From: Bernadette Owens
Sent: 08 October 2021 07:32
To: DC Support
Subject: FW: 21/03150/REM - Begbroke Science Park, Begbroke Hill, Begbroke

From: Tim Screen <Tim.Screen@Cherwell-DC.gov.uk>
Sent: 07 October 2021 15:46
To: Bernadette Owens <Bernadette.Owens@Cherwell-DC.gov.uk>
Subject: 21/03150/REM - Begbroke Science Park, Begbroke Hill, Begbroke

Illustrative Landscape Masterplan

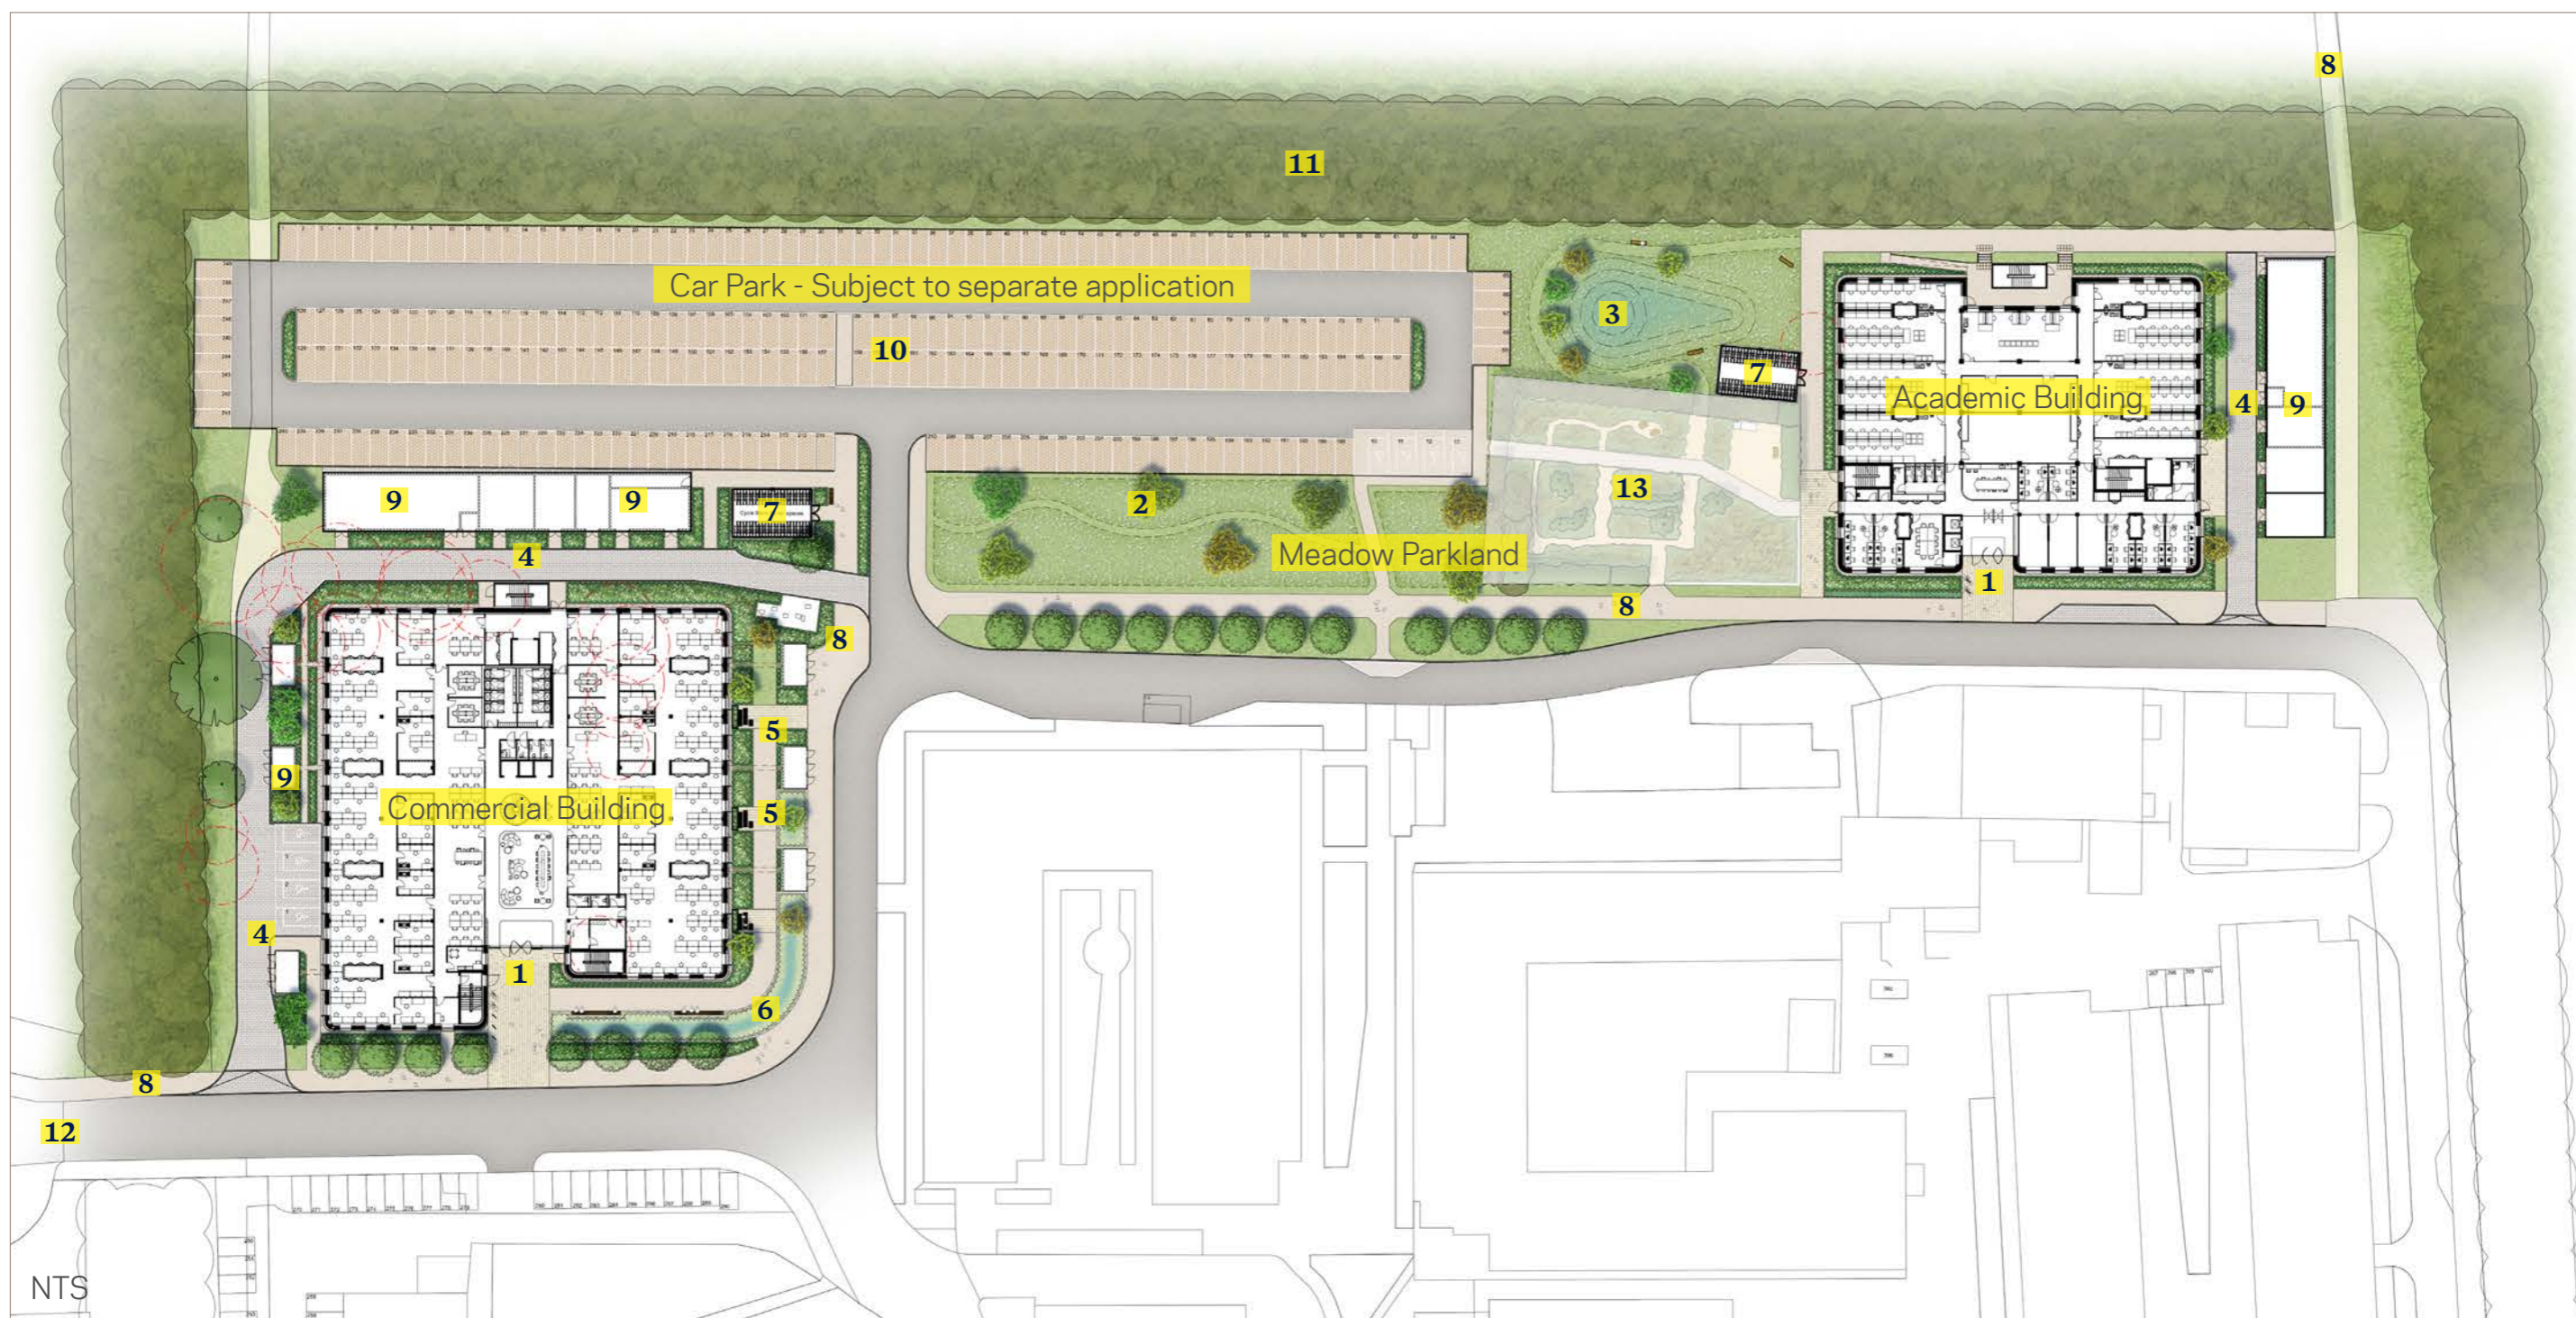
The Landscape Masterplan and the Planting Plans 1 and 2 are also acceptable. However, I was unable to find tree pit planting details on the DEF system. If these details can be forwarded to me that would be appreciated.

NB. (Additional comment from Landscape Architect) heavy standard trees should be included in the car park to mitigate the heat island effect.
